Consultation Response from KC, Lead Local Flood Authority		
2021/91638 Land at Hart Street, Newsome, Huddersfield, HD4 6LS		
Reserved matters application pursuant to outline application no.2016/91479 (appeal no. APP/Z4718/W/17/3173711) for erection of 22 dwellings		
Date Responded: 7th June 2021	Responding Officer: Paul Farndale	Responding Ref:

PLANNING
DRAWING

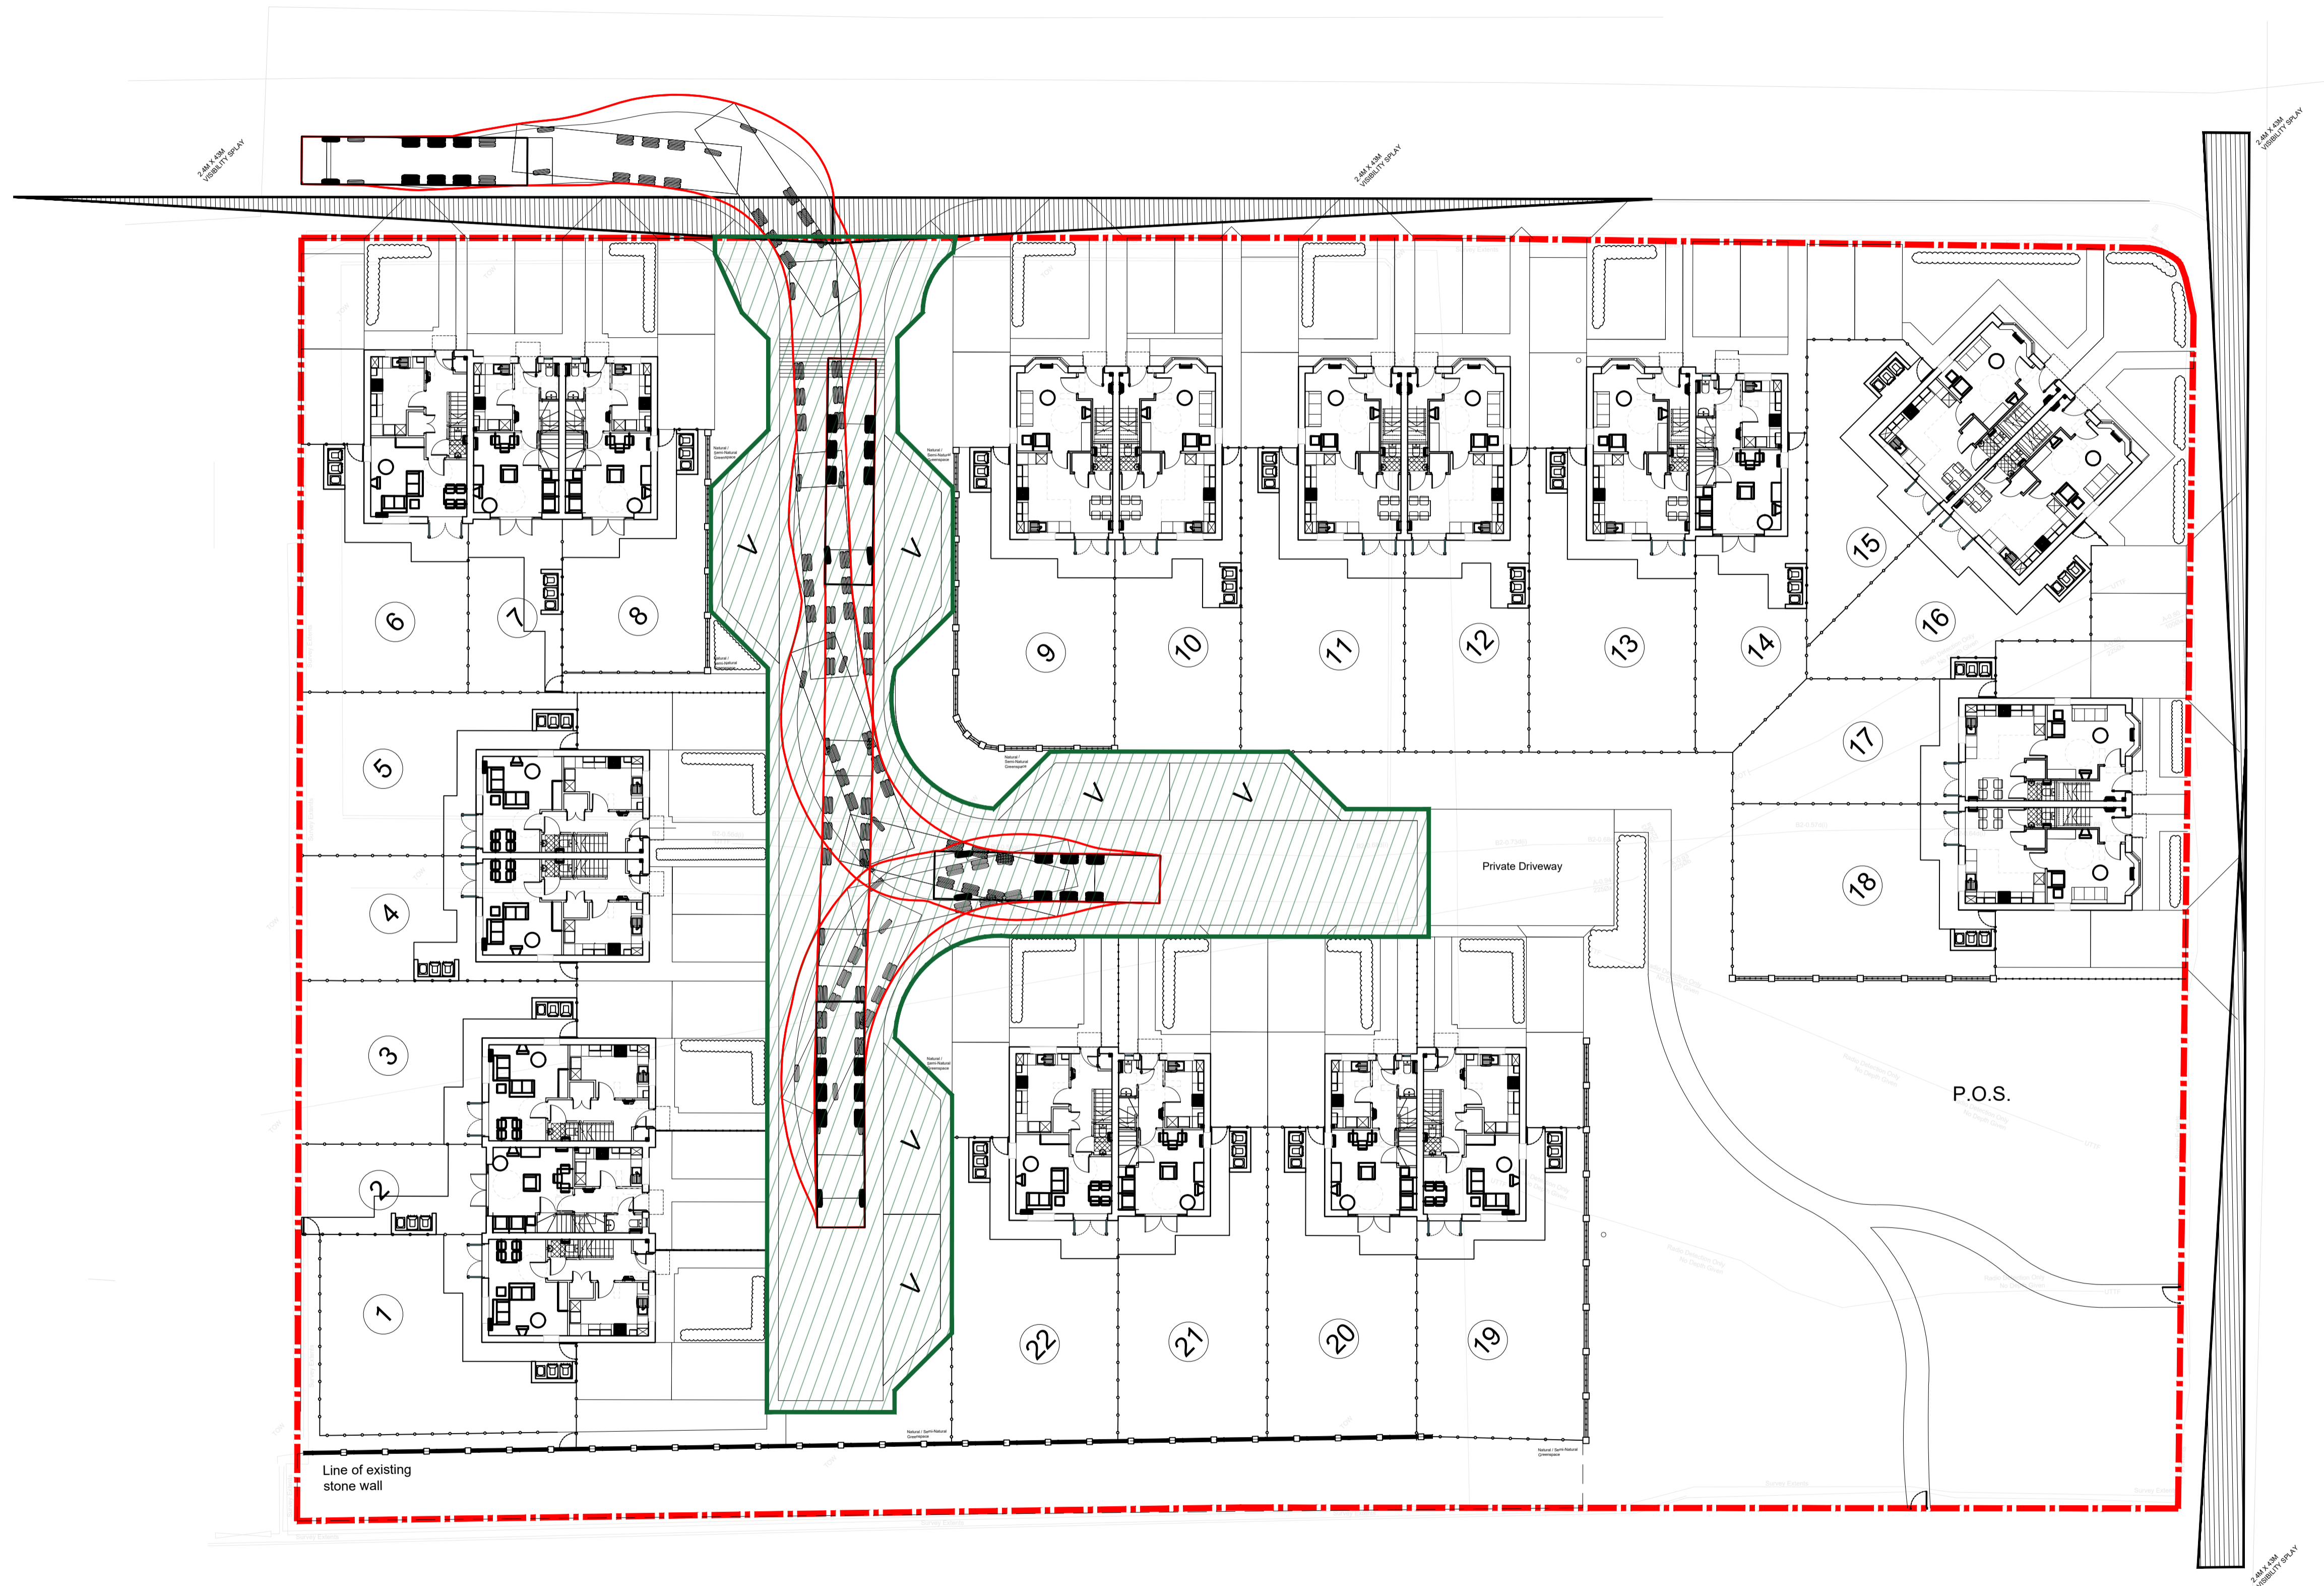
Kirklees Flood Management & Drainage acting as LLFA, statutory consultees for surface water, OBJECT to this application on the grounds that there is no demonstration within the layout design that ‘space has been made for water’.

The layout will need to accommodate diversion of the watercourse through the site and connect back into public sewer. Although not submitted with the application we are satisfied that work has been completed proving that the watercourse via ponds connected into the public combined sewer.

The layout will need to accommodate separate foul and surface water systems. The latter will include attenuation requirements. We believe that the area of the ponds should be taken into account as previous direct discharge, of which a 30% improvement on peak flows should be achieved in accordance with Kirklees’ Local Plan Policy.

Flood routing from catchment and site exceedance and blockage events should avoid curtilage where reasonably practicable.

None of the above has been demonstrated to conclude that a safe layout has been designed around these constraints.
